PLANNING CONSULTATION RESPONSE

Application No	2026/0397 & 0368
Proposal	2026 0397 & 0368 Variation of Condition 2 LBC & PP of 2025 0244& 0161 Mixed Use Scheme Penistone Coal Drops Regency House Land at St Mary's House St Mary's Street Penistone
Address	Penistone Coal Drops Regency House Land at St Mary's House St Mary's Street Penistone
Date of Consultation Reply	290726
Consultee	Tony Wiles Senior Conservation Officer

New Proposed Elevations

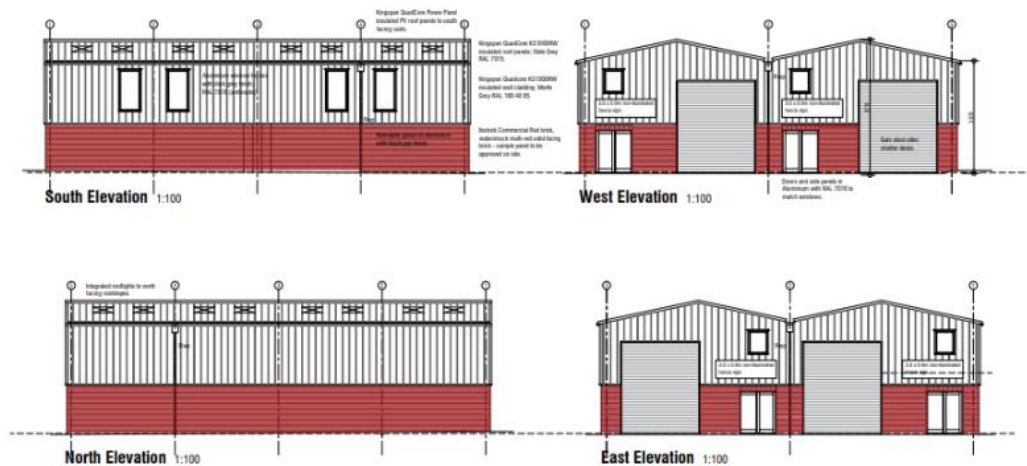
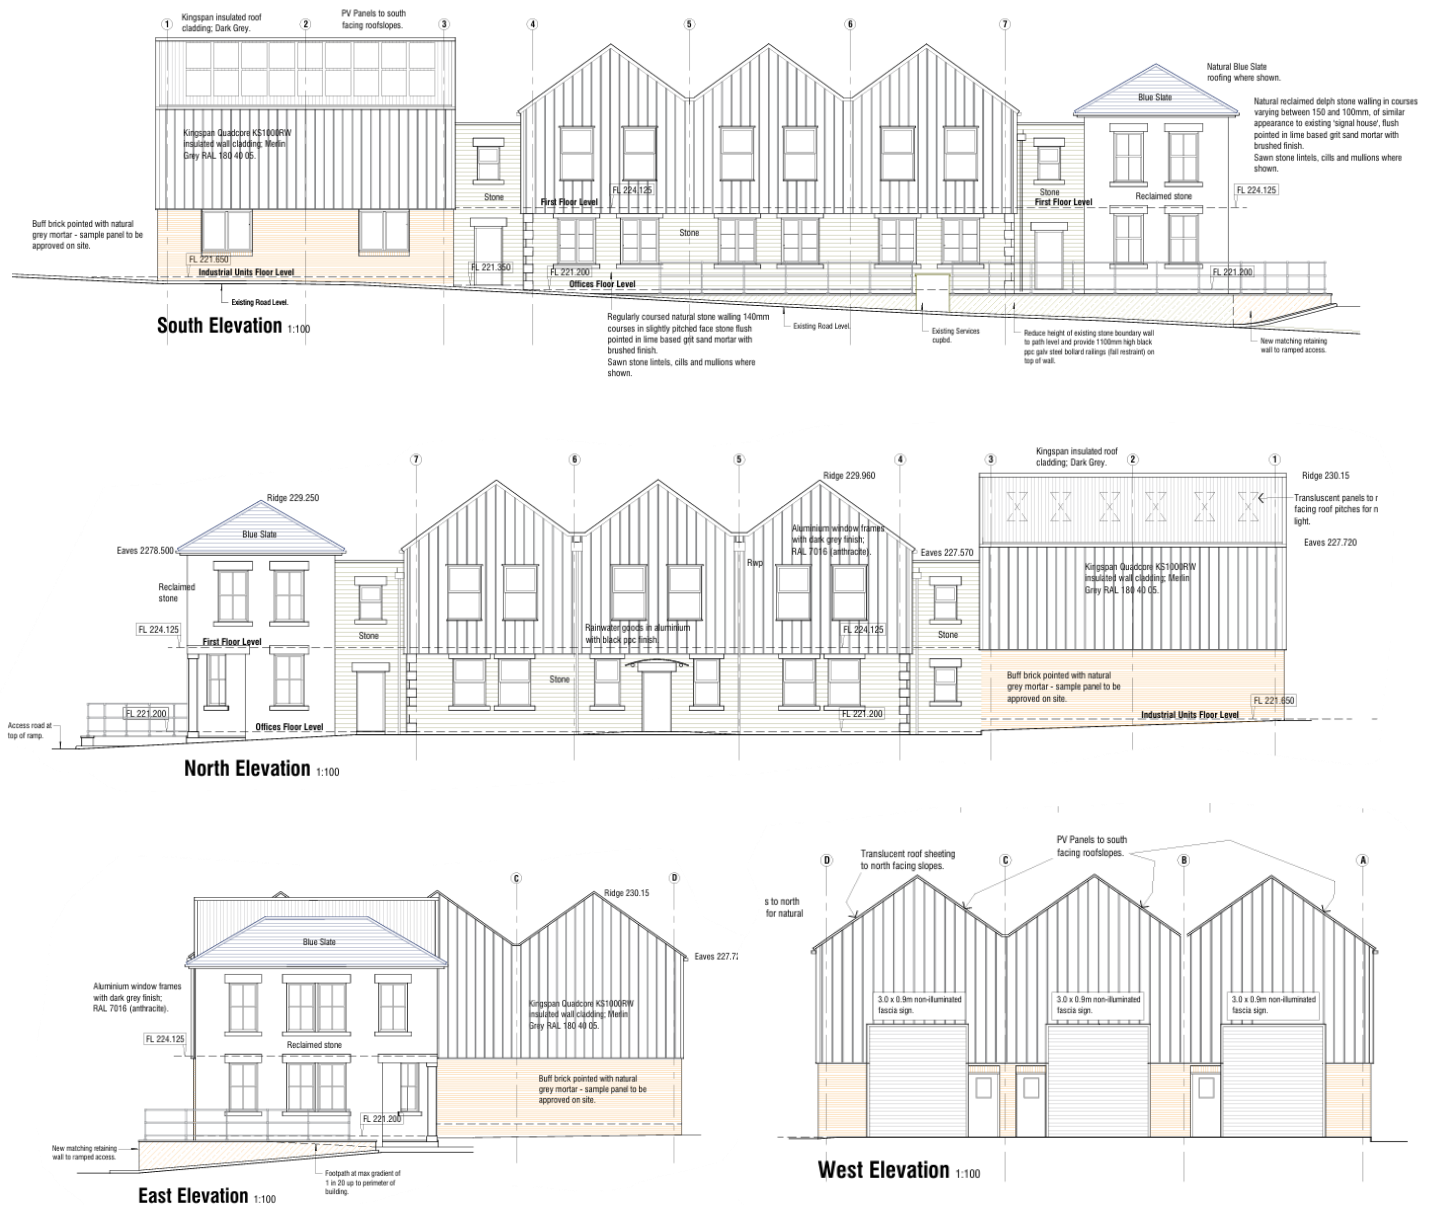
- The design of the industrial units, which has been substantially simplified;
- Amendments to the design of the office building, specifically the easternmost element which bookends the unit with the hipped roof. This element is now more traditional in appearance, using stone, slate, and a more traditional sash window design, rather than the previously approved contemporary approach;
- The design of the flat-roofed linking elements, which are now proposed wholly in stone, where previously they incorporated a combination of stone and glazing;
- Changes to the cladding materials proposed for the upper levels of both the office block and the industrial units above the stone and brick plinth;
- A change in brick choice from buff brick to a red lbstock brick.

By way of context, my primary focus remains the listed Coal Drops, Regency House and the development at the eastern end of the site, which is unchanged by these amendments. As previously noted, this is a sensitive and prominent location, with the eastern part of the site close to an important gateway into Penistone. The principle of the pavilion building above the Coal Drops was established in 2013 and, in my view, continues to work well in this location and setting. The repair and adaptation of the Coal Drops and Regency House would clearly represent a significant heritage benefit within the overall development. However, I am disappointed that the design of the industrial units has been simplified to such a degree. While the unit at the western end of the site lies outside the conservation area, the whole of the office building and its attached light industrial unit fall within it. In particular, I feel that the unit attached to the office building now lacks the design quality and architectural articulation of the approved scheme and lessens the quality of the office building overall. The detached industrial unit at the western end of the site is similarly reduced in quality when compared with the approved proposals. Taken together, the revised forms of the industrial units, the introduction the amended cladding material in place of standing seam zinc, and (potentially) the red brick plinths result in a less successful overall appearance. As such I feel this no longer complements the conservation area or the setting of the listed building to the same extent as the approved scheme. I acknowledge that a degree of value engineering may be necessary to help secure delivery of the development as a whole. I am also mindful that the safeguarding and conservation of the Coal Drops and Regency House, together with improving the overall appearance of this prominent gateway site, remain important objectives. That said, I'd suggest that design changes to the industrial buildings should be looked at to make them appear less visually jarring and more in keeping with the setting of the conservation area. In any event, I am sure the materials could be improved upon to better harmonise the appearance of the industrial units with the rest of the development and the wider setting.
